DELEGATED DECISION TO DETERMINE PLANNING APPLICATIONS

Reference No:	2025/62/93504/W
Site Address:	2, Peace Hall Drive, Fenay Bridge, Huddersfield, HD8 0BP
Description:	Demolition of existing conservatory and erection of single storey rear extension and front porch with associated alterations
Recommending Officer:	Molly Storer

HOUSEHOLDER DELEGATED REPORT

AS PROPOSED, SITE PLAN(S) + AS EXISTING / PROPOSED
LOCATION PLAN

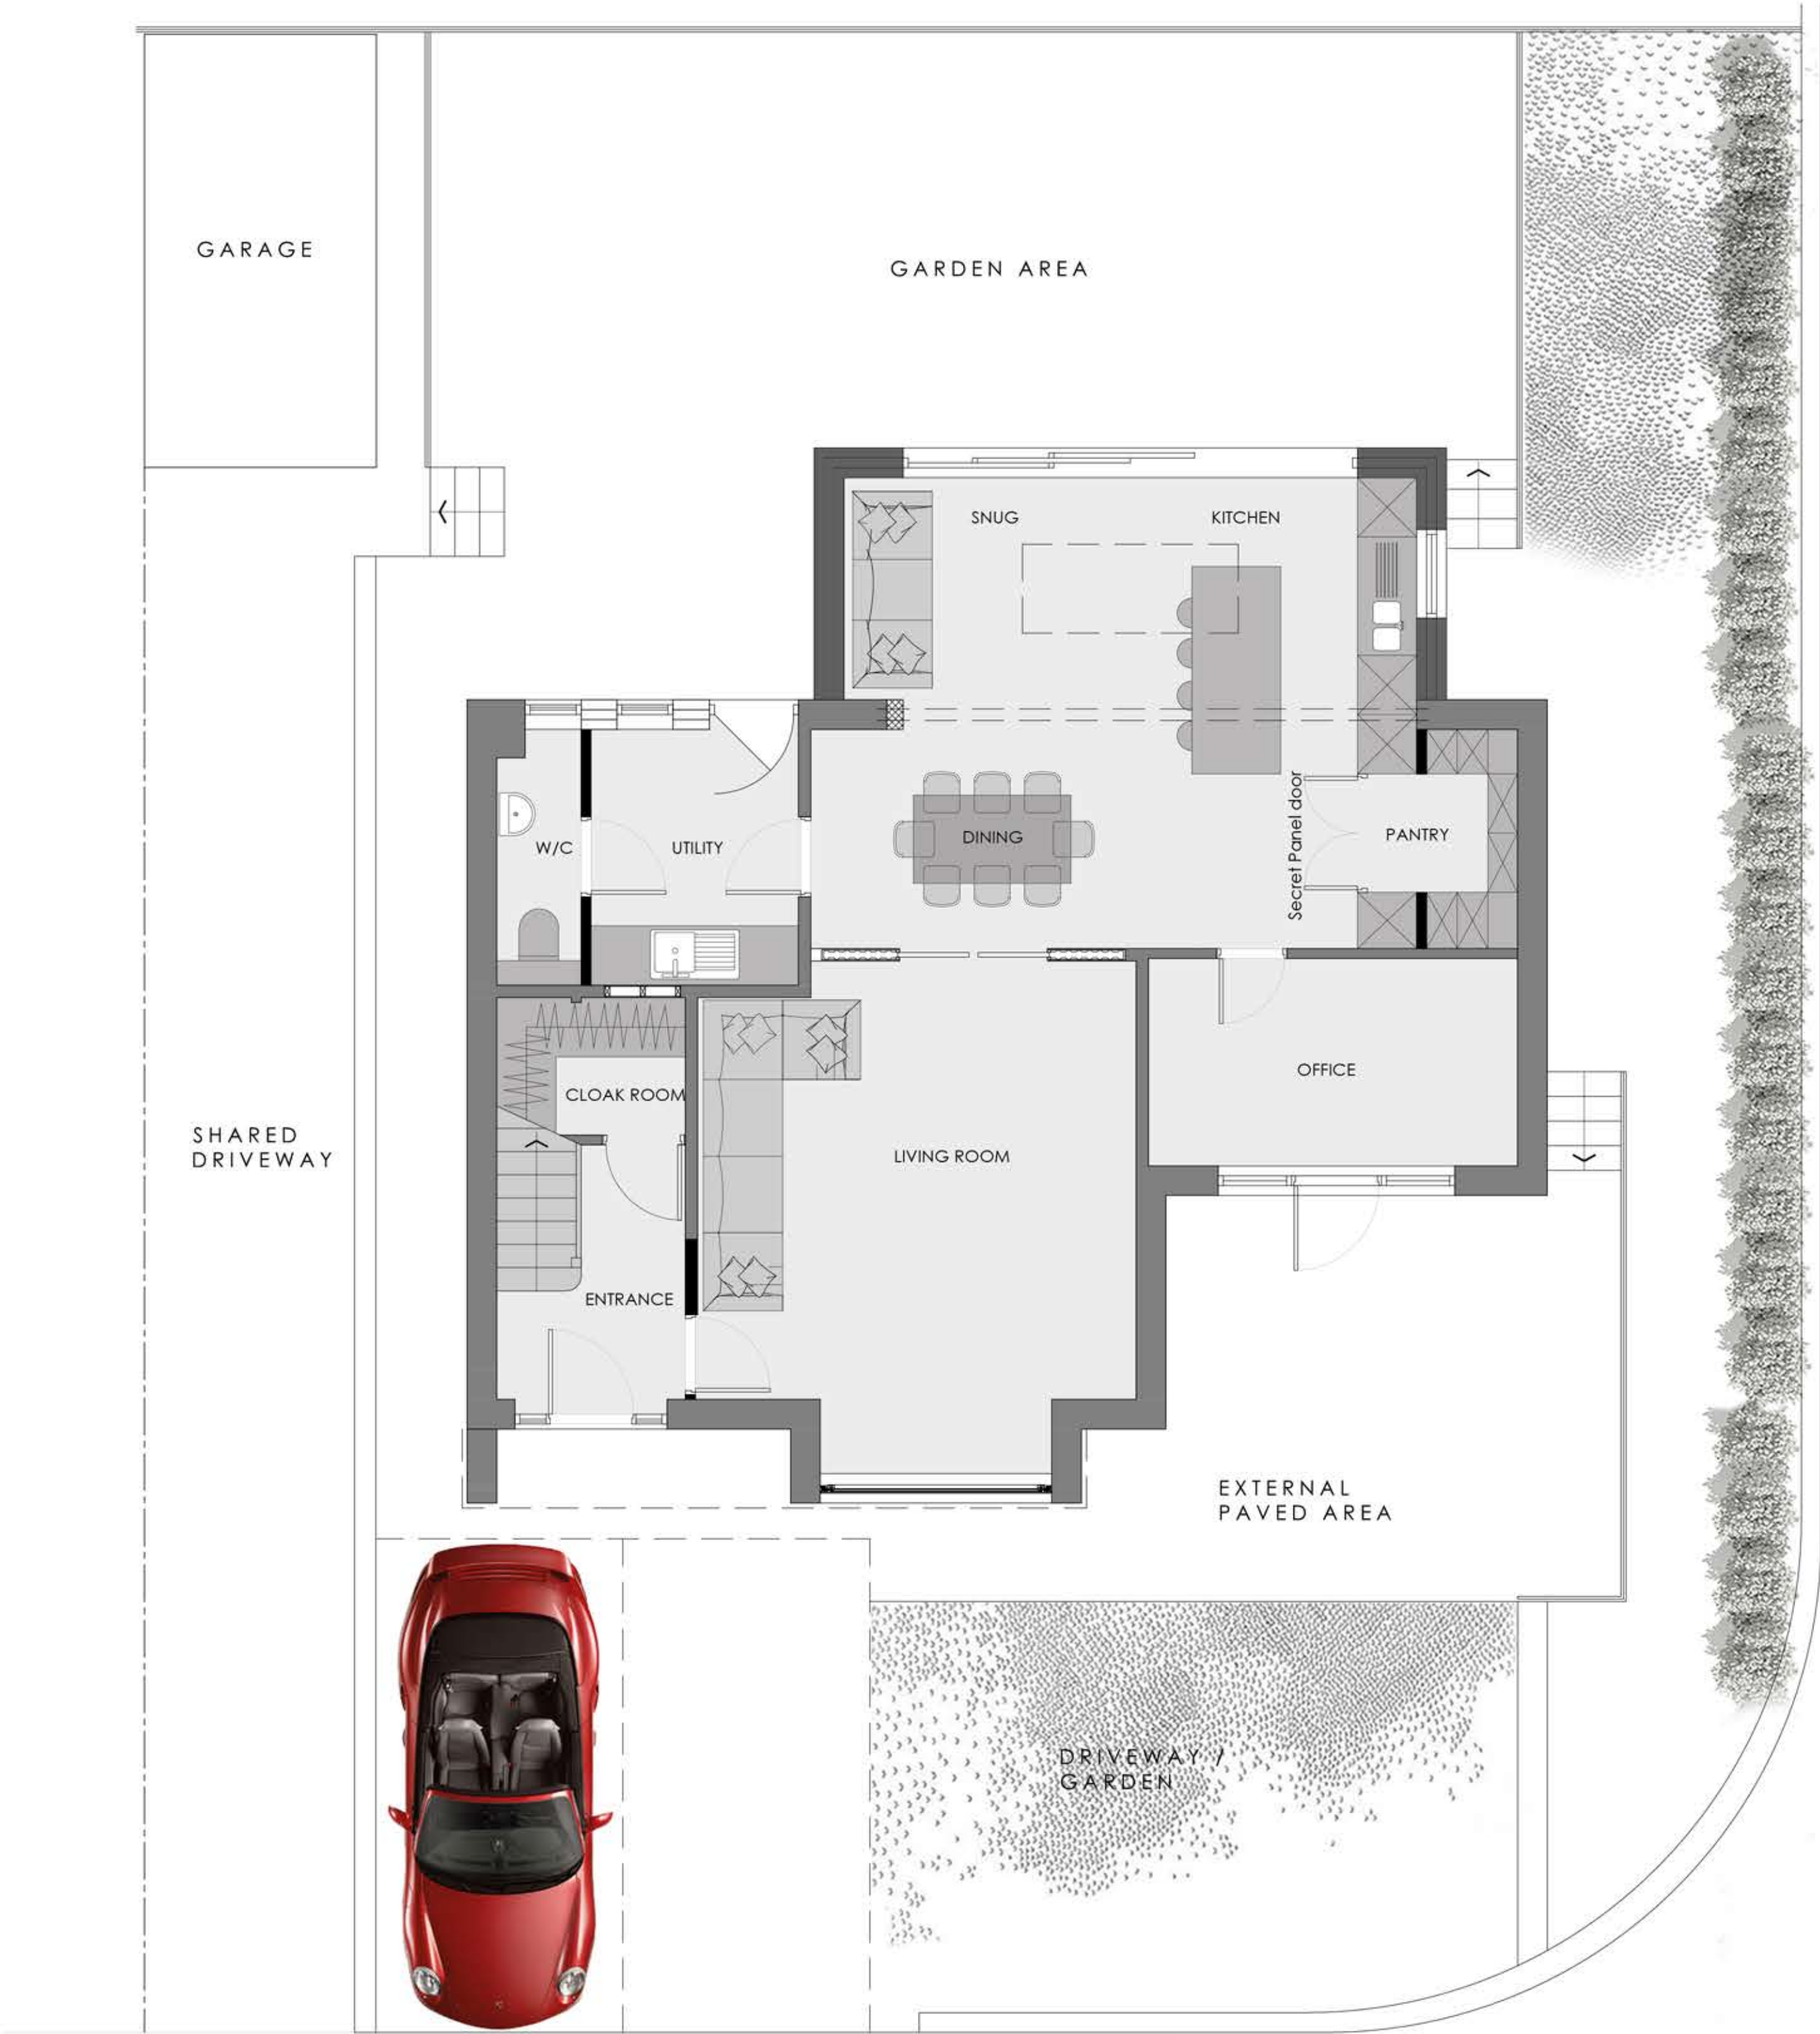
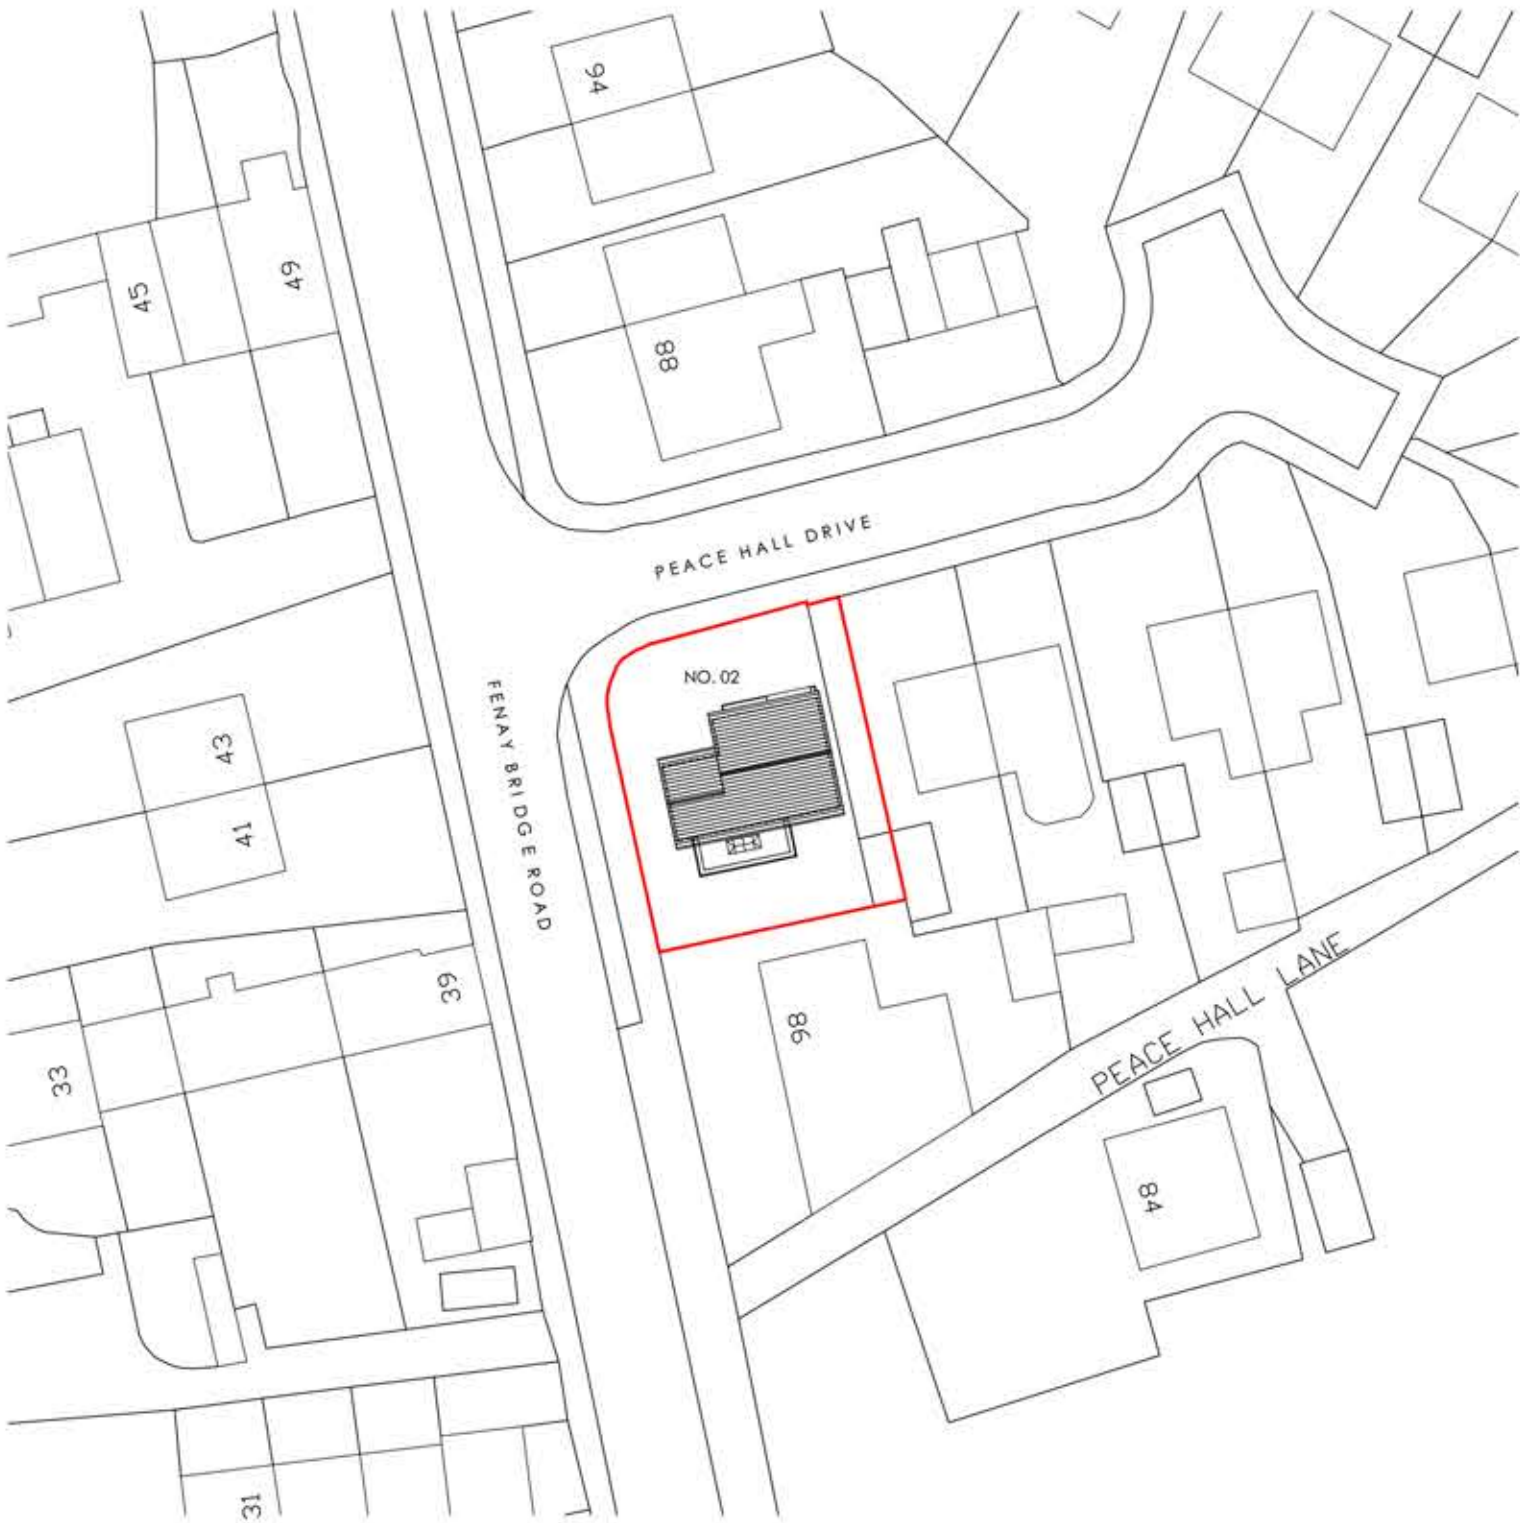
Other alterations include an external paved area to the front of the house and recladding of the first floor.

Remaining garden space of application property	• KDP 7 of the SPD • Policy LP24 Design (b) and (c) • Chapter 12 of the NPPF	Acceptable level of remaining garden space	✓
